# **Application by Highways England for an Order Granting Development Consent for A57 Link Roads**

## **The Examining Authority's third written questions and requests for information**

### **High Peak Borough Council's Response**

© OpenStreetMap (and) contributors. CC-BY-SA
 Contains OS data © Crown Copyright and database right

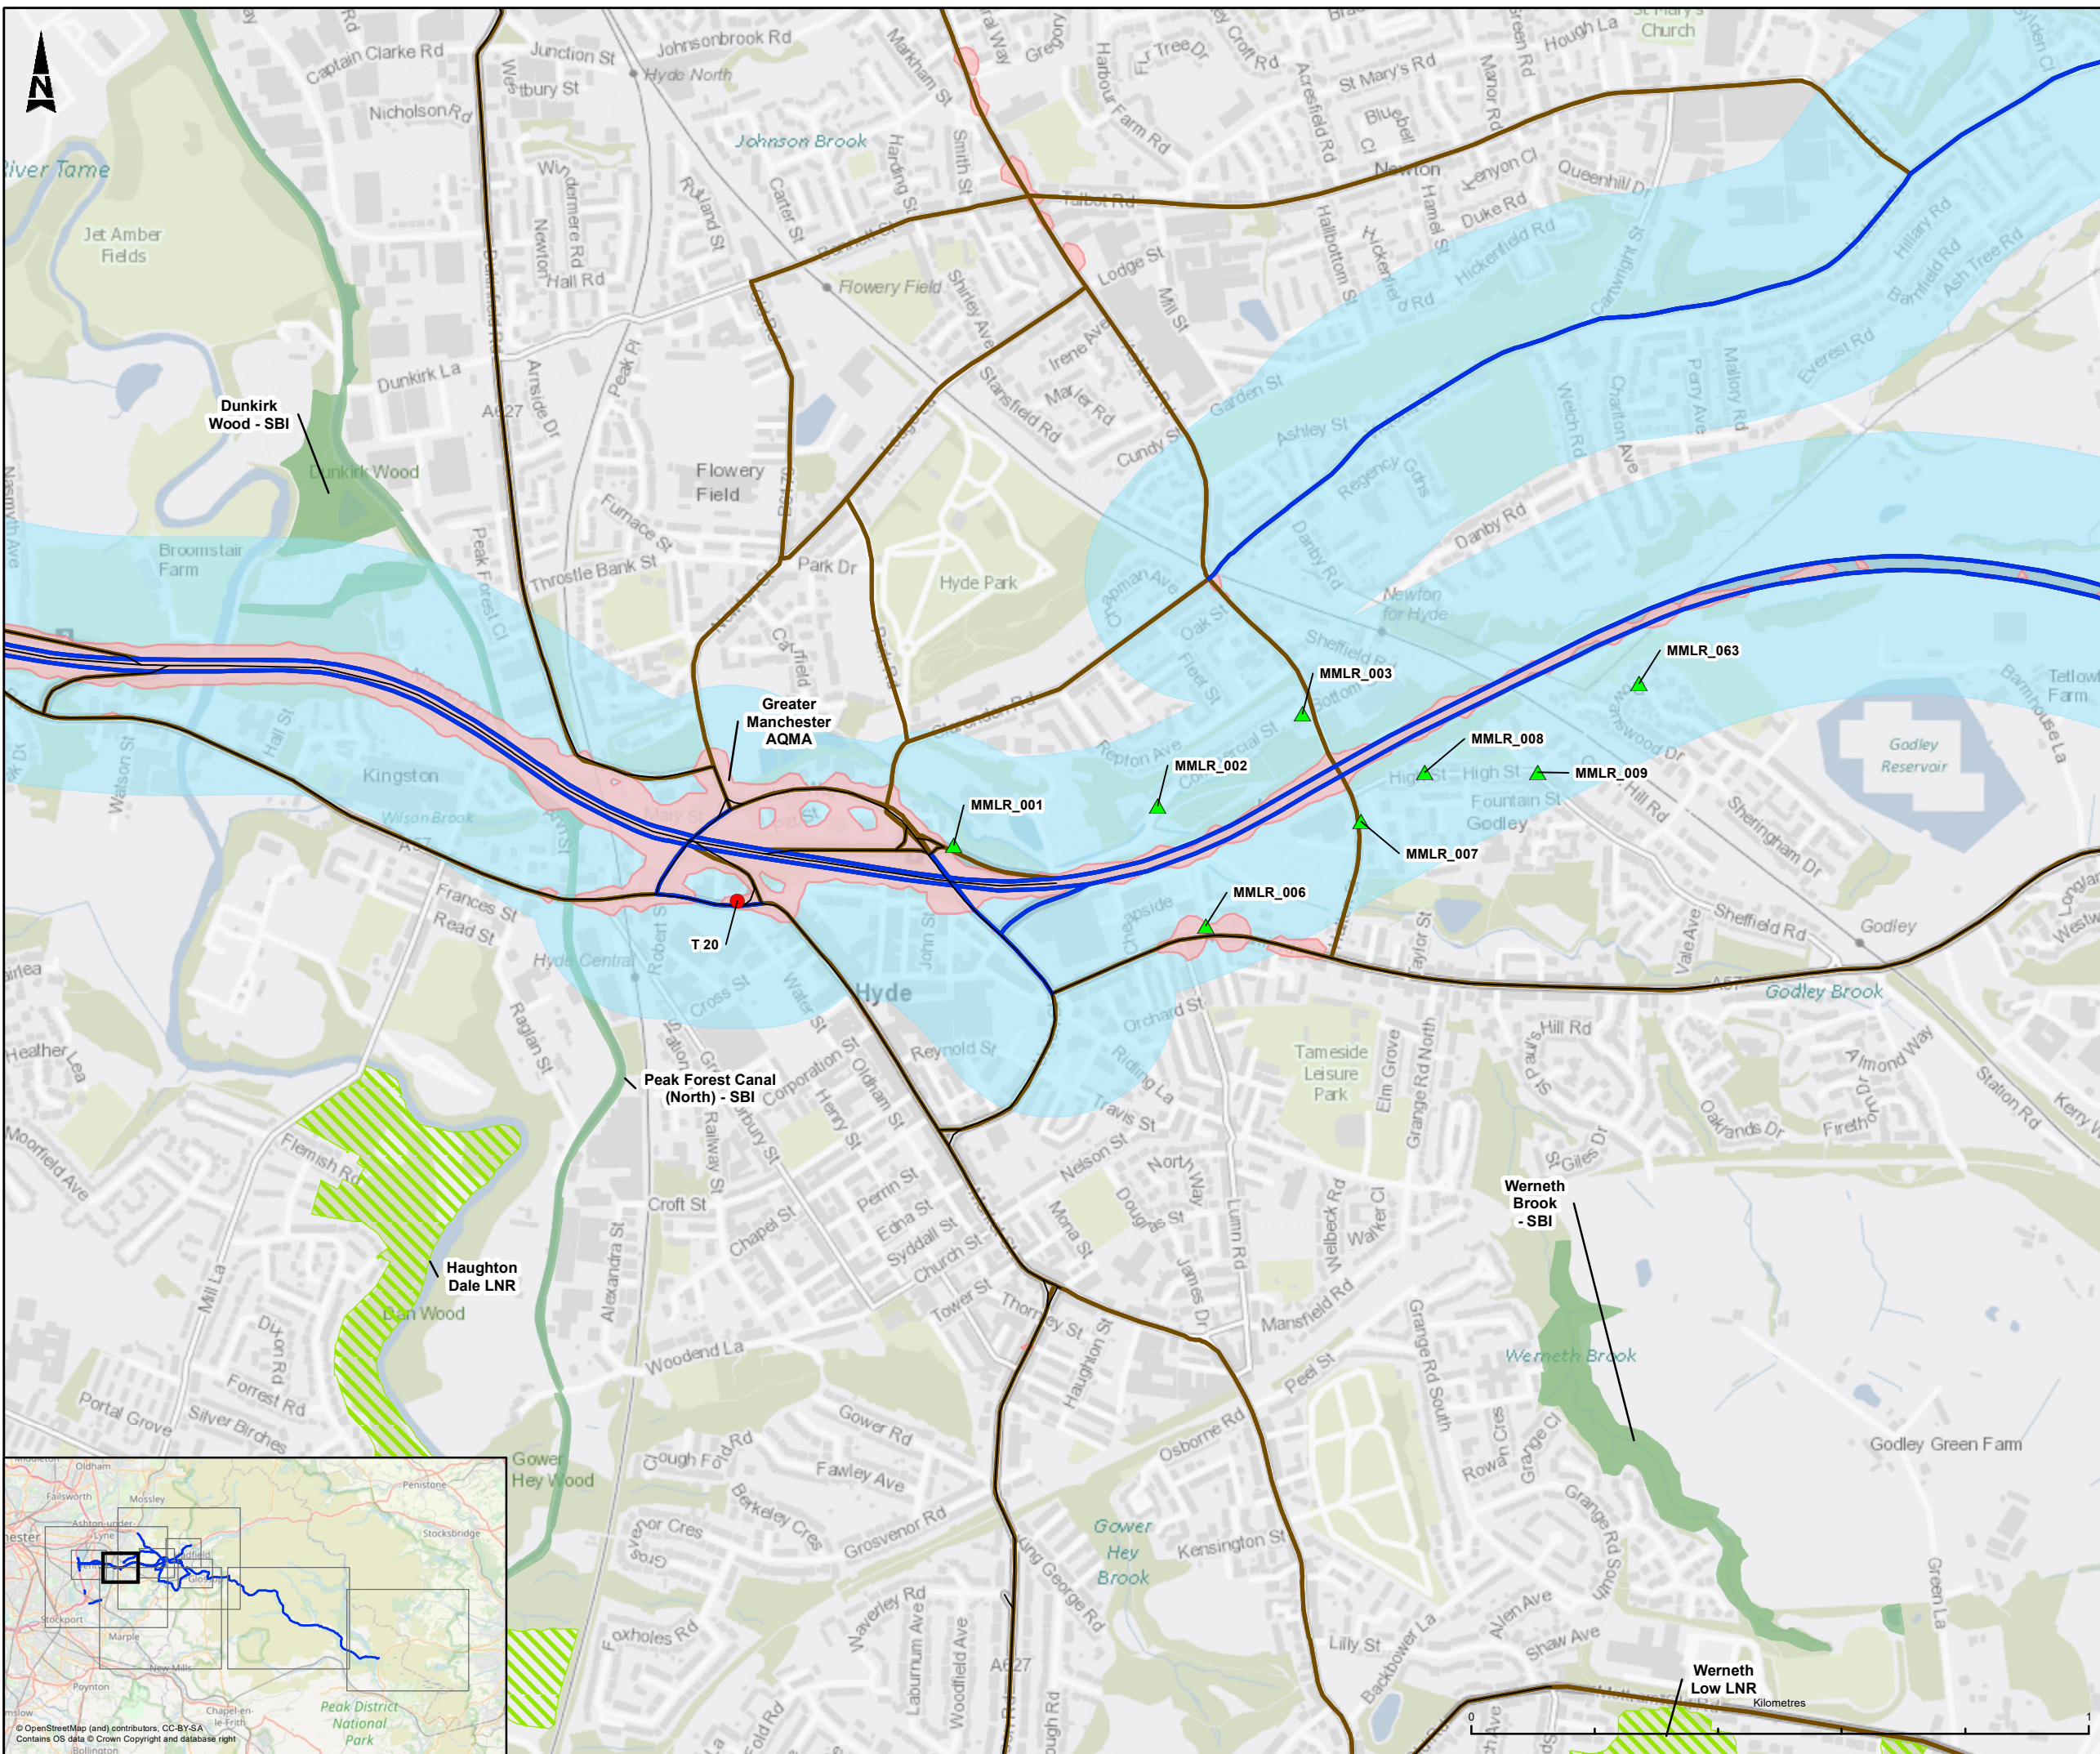
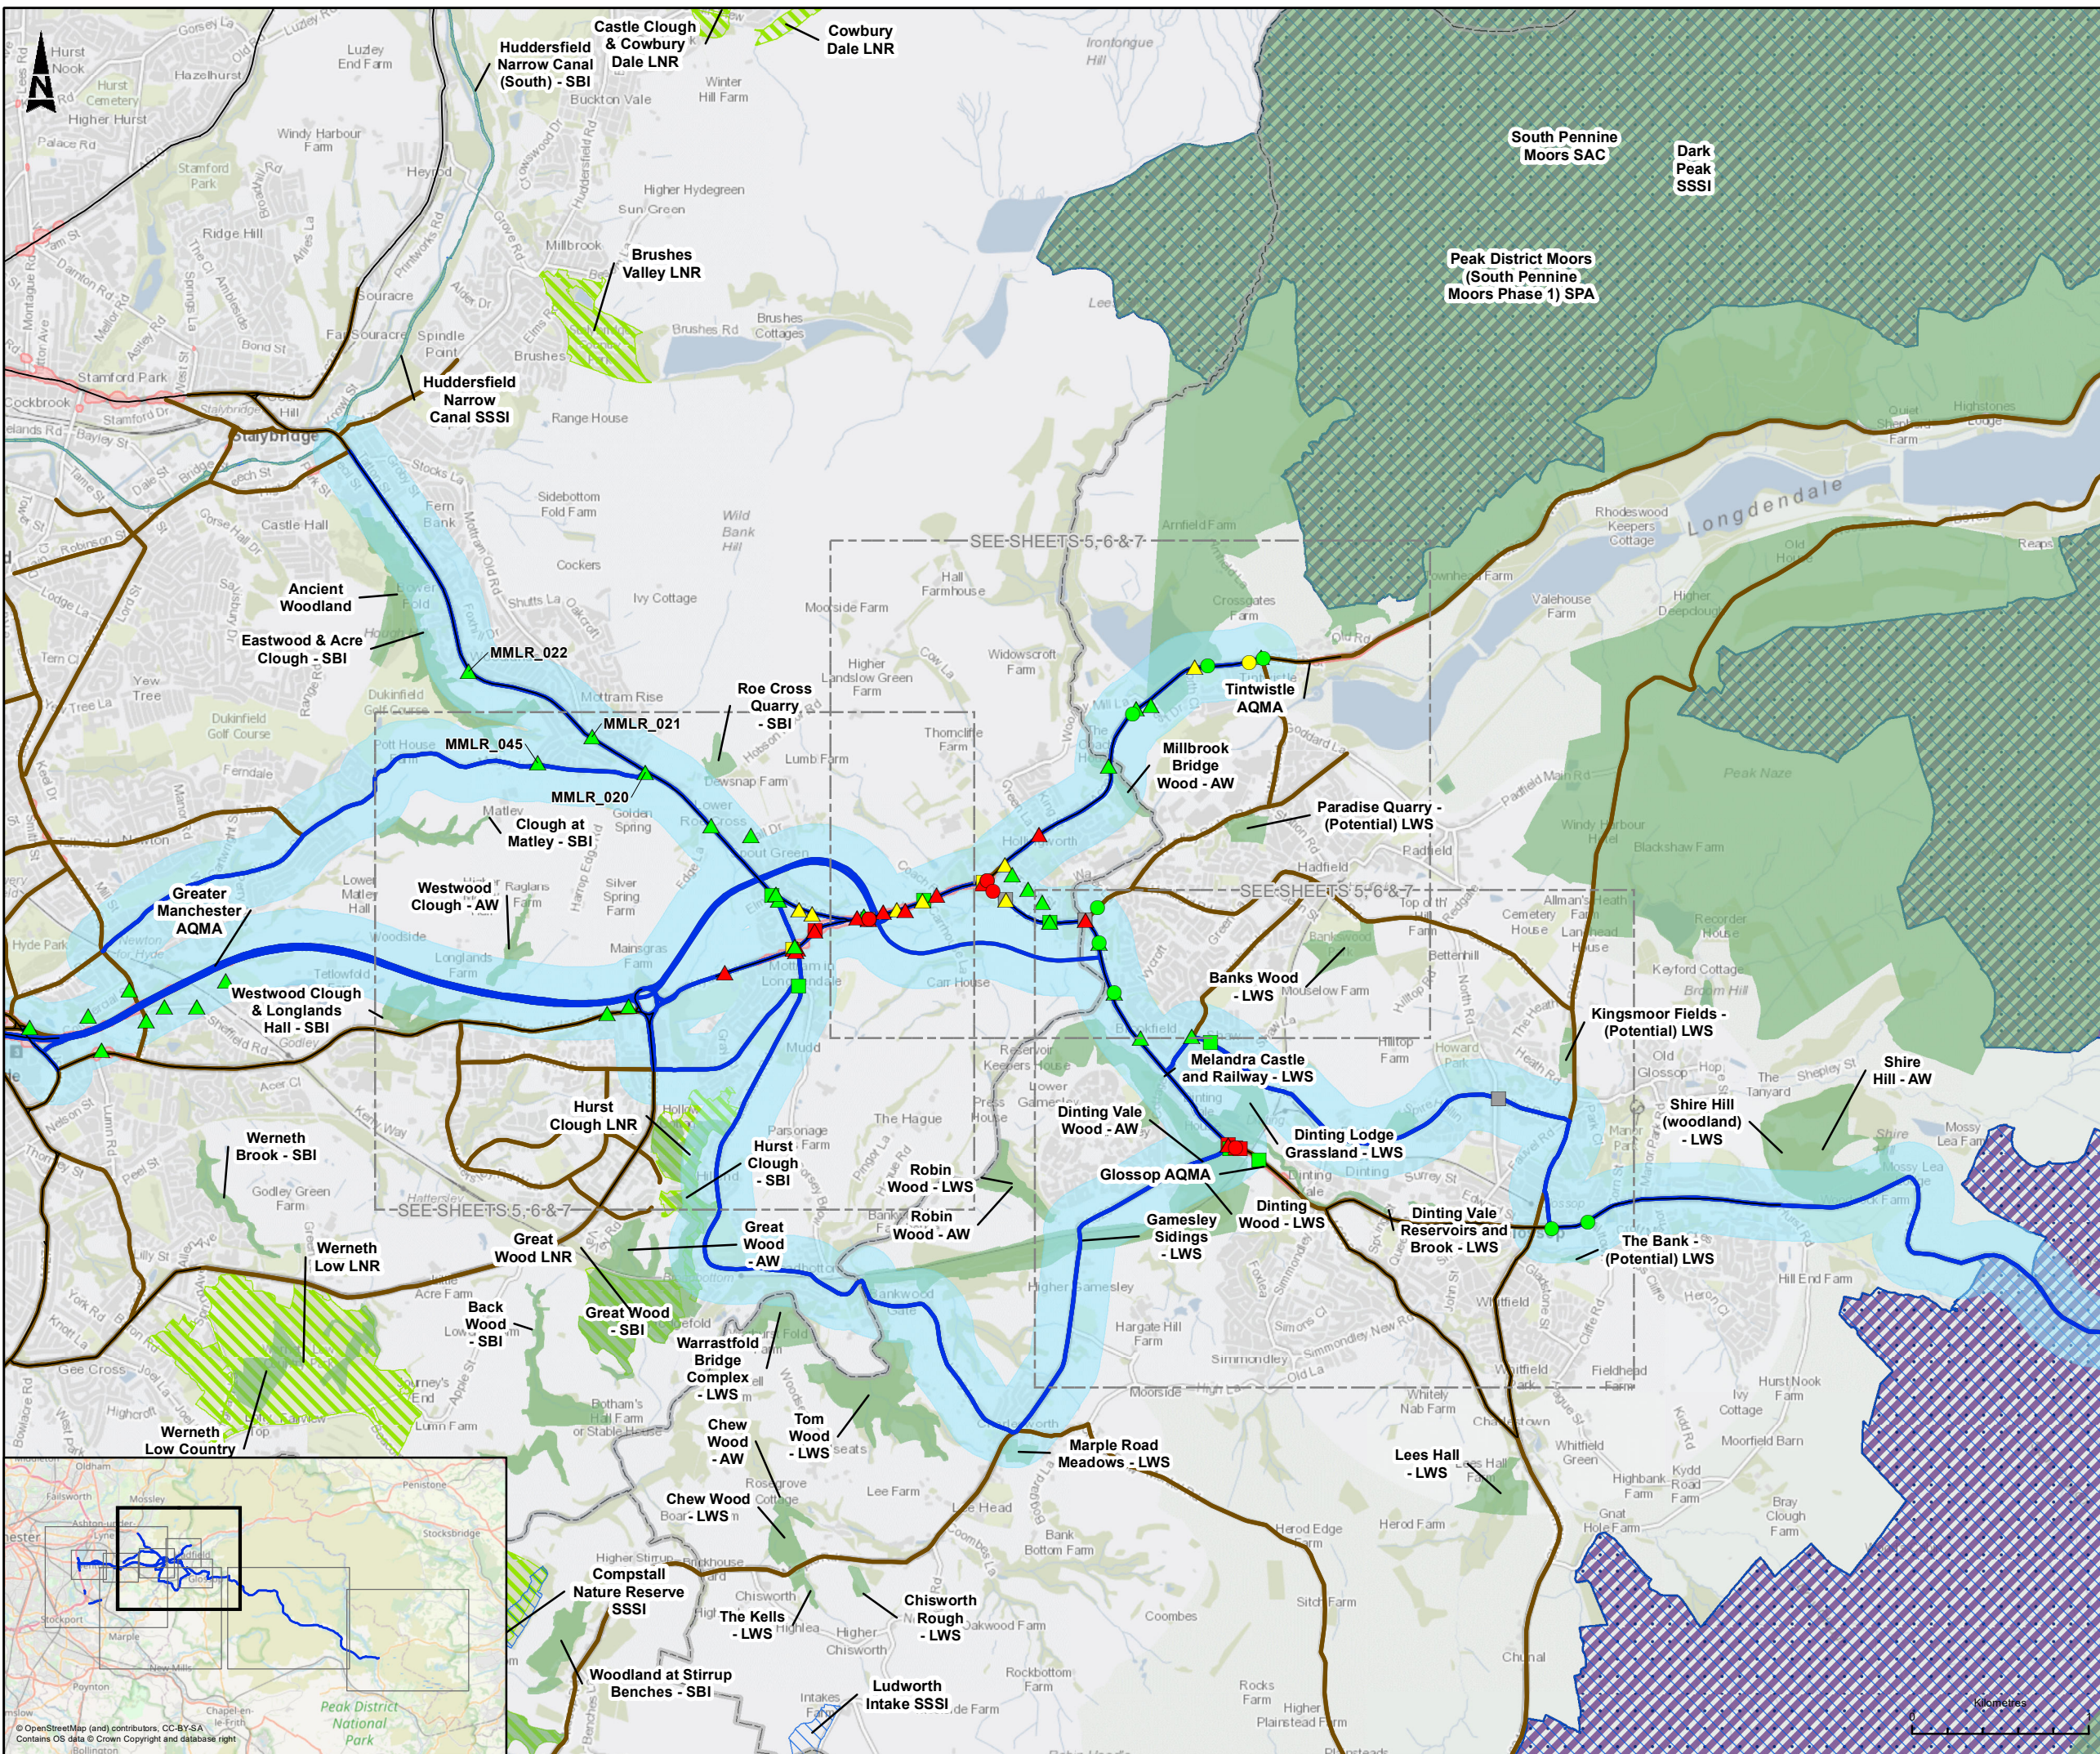
HPBC’s key concern remains that impact of the scheme on the designated AQMAs, should have been included on a precautionary basis;

However, as noted, there remains concerns over the accuracy of the traffic data that used to drive the scoping criteria, Notably, the changes in traffic numbers and/ or changes in speed bands.
